From: [REDACTED]
Sent: 17 February 2020 09:04
To: Planning.Responses <Planning.Responses@arun.gov.uk>
Cc: bernadette.gledhill@westsussex.gov.uk; Michael Eastham <Michael.Eastham@arun.gov.uk>
Subject: Response To Application Number LU/366/19/DOC at Fitzalan Link Road Littlehampton

TO:	Arun District Council FAO: Michael Eastham
FROM:	WSSC - Highway Authority: Tim Townsend
DATE:	17th February 2020
LOCATION:	Fitzalan Link Road Littlehampton
SUBJECT:	LU/366/19/DOC Approval of details reserved by condition imposed under ref LU/234/16/RES relating to Condition No 7 - acoustic barrier.
DATE OF SITE VISIT:	DESKTOP STUDY
RECOMMENDATION:	Advice
S106 CONTRIBUTION TOTAL:	n/a for this application

Drawing Title:
PROPOSED S38/S278 HIGHWAY WORKS
FITZALAN LINK
LANDSCAPE PROPOSALS - ACOUSTIC FENCE 1 OF 2

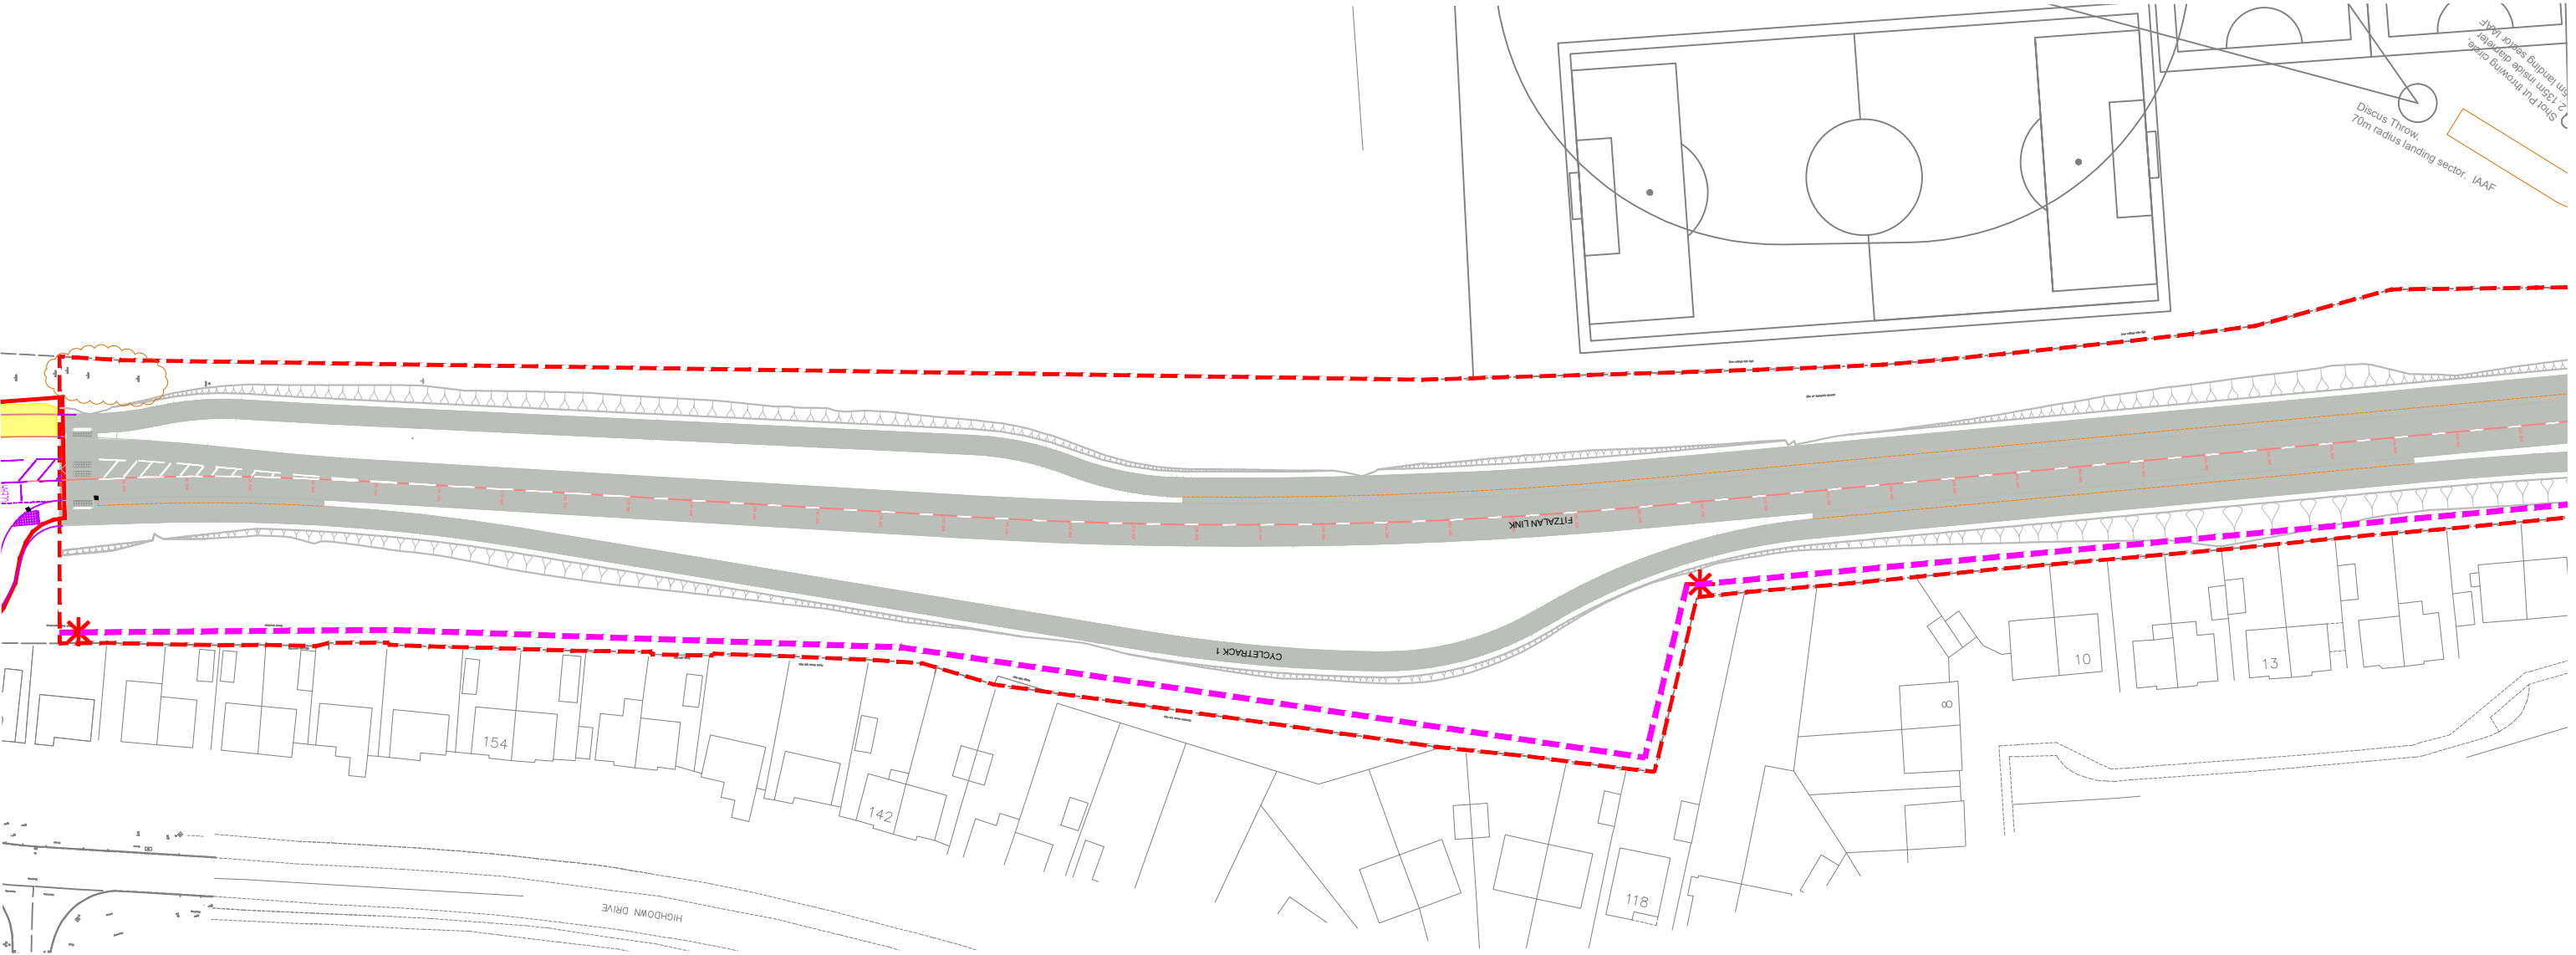
The CHA has considered the barrier as submitted (GRAMM METASoundBlok) and can confirm that this in terms of the type, location thereof and suitability for maintenance purposes etc., the barrier is acceptable subject to the caveats contained below.

- 1. Adoption of acoustic barrier** – The CHA is prepared to take-on the maintenance of the barrier but only subject to an appropriate design being agreed and upon payment of a suitable commuted payment by the developer (which will be calculated at the S38/278 stage). If neither design nor figure can be agreed, the maintenance will have to be undertaken by others.
- 2. Interaction with walking and cycling routes** – At the S38/278 stage, a staggered barrier (or similar) will need to be considered adjacent to where Public Footpath 3103 emerges between the barrier from Highdown Drive.
- 3. Structures 'Approval in Principle' (AIP)** – Technical approval procedures for the acoustic barrier in accordance with BD2/12 will need to be followed' post-planning as part of the overall S38/S278 application.
